WISWELL PARISH COUNCIL

Planning Application No: 3/2012/0338
New agricultural store to replace existing sheds
2 Whiteacre Lane, Barrow, Clitheroe, Lancashire, BB7 9BJ

1:500 SITE PLAN

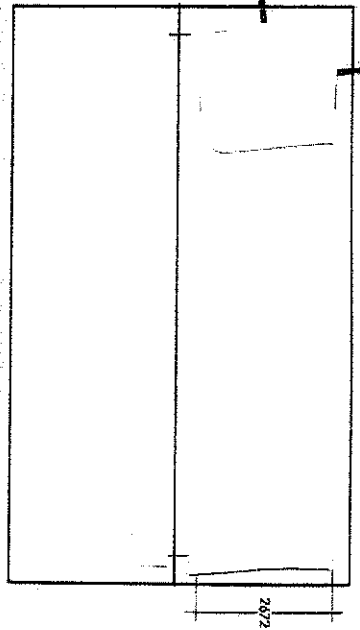
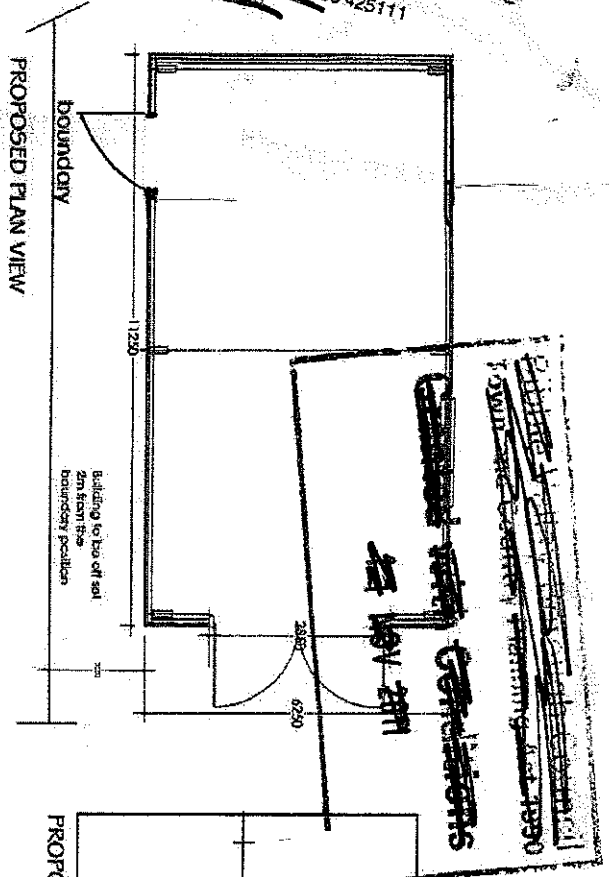
1. The sighting of the store is directly behind a neighbouring property and appears to be visually obtrusive to nearby residents.
2. The sighting of the store directly behind a neighbouring property could have a detrimental environmental effect on nearby residents.
3. The Councillors would like to query the regulations for keeping livestock in such an environment, surrounded by residential properties.
